KIRKLEES METROPOLITAN COUNCIL INVESTMENT & REGENERATION SERVICE

DELEGATED DECISION TO DETERMINE APPLICATIONS FOR NON-MATERIAL AMENDMENTS

Reference No: **2026/NM/92032/W**

Description: Non material amendment to previous permission
2024/92647 for erection of detached dwelling with
detached garage

Drawing title
Bungalow Elevations as Proposed

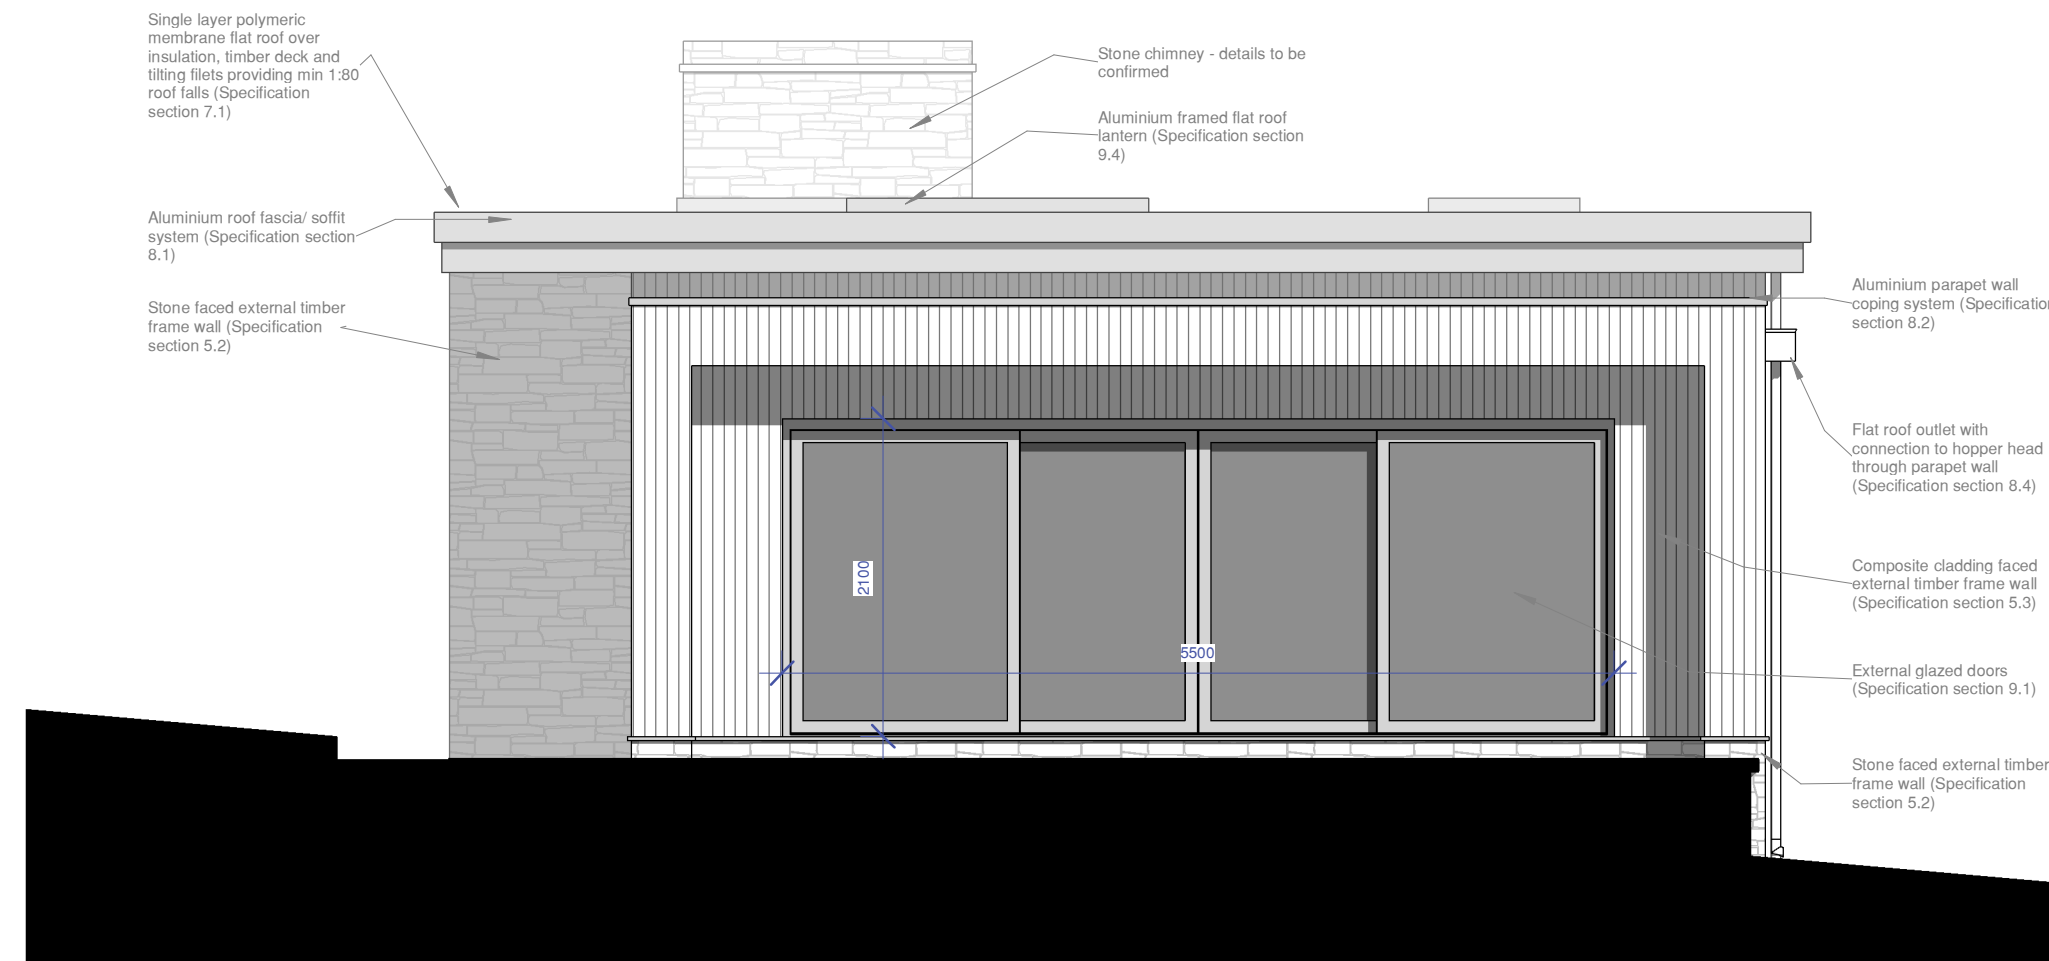
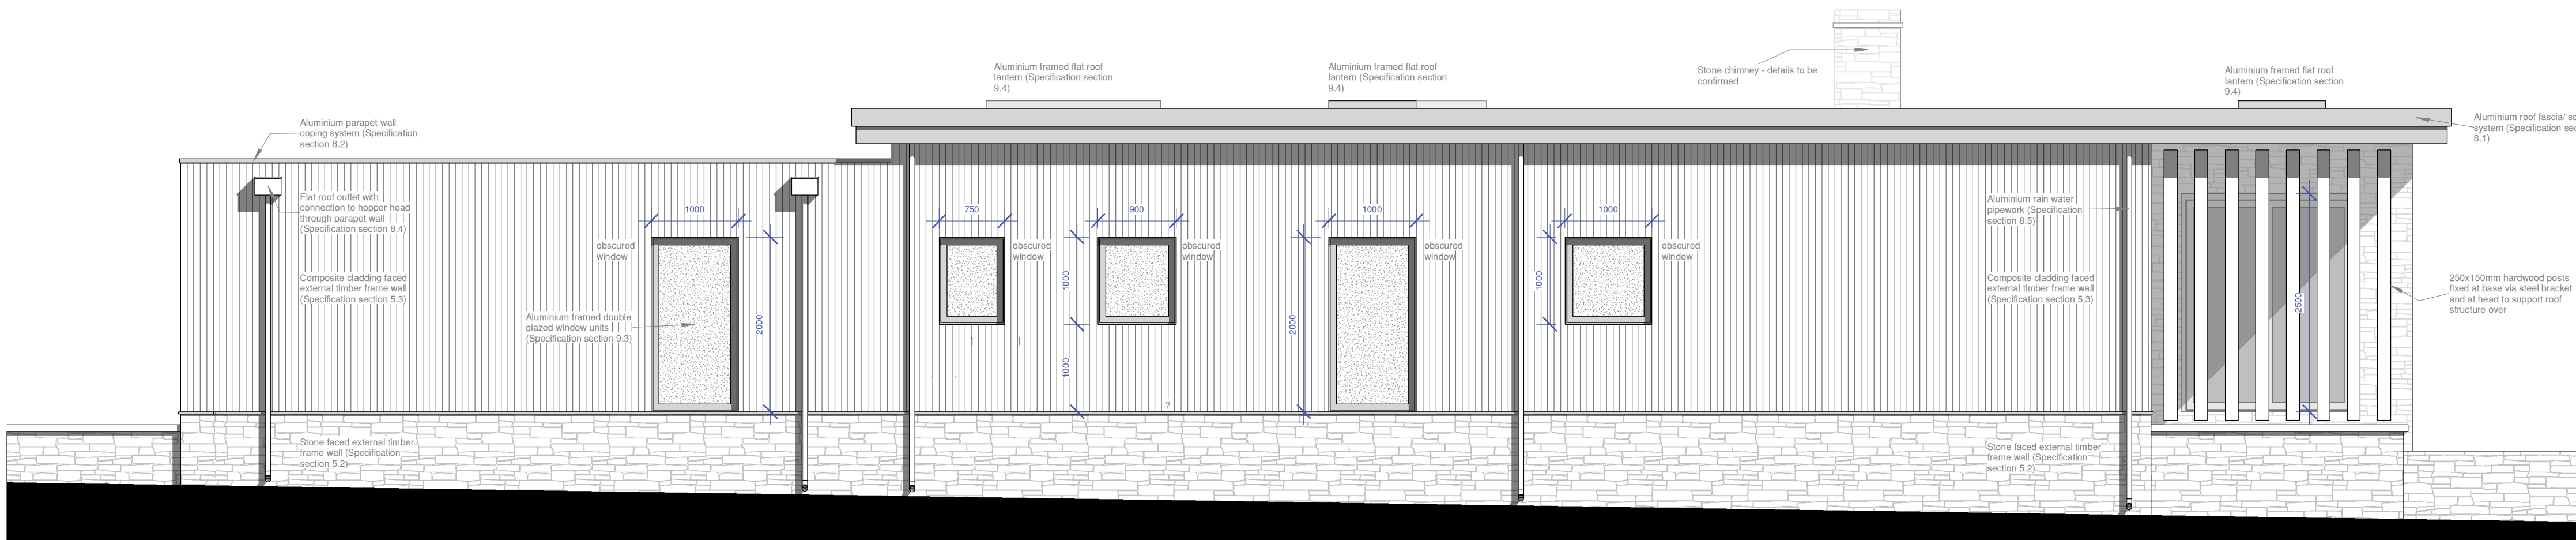
The proposed amendments would result in a greater built form and a different impact when compared to the approved scheme. The changes would

Comment: The proposed changes would require a further restriction to make it acceptable. Potentially use of / additional conditions may be required in relation to openings proposed
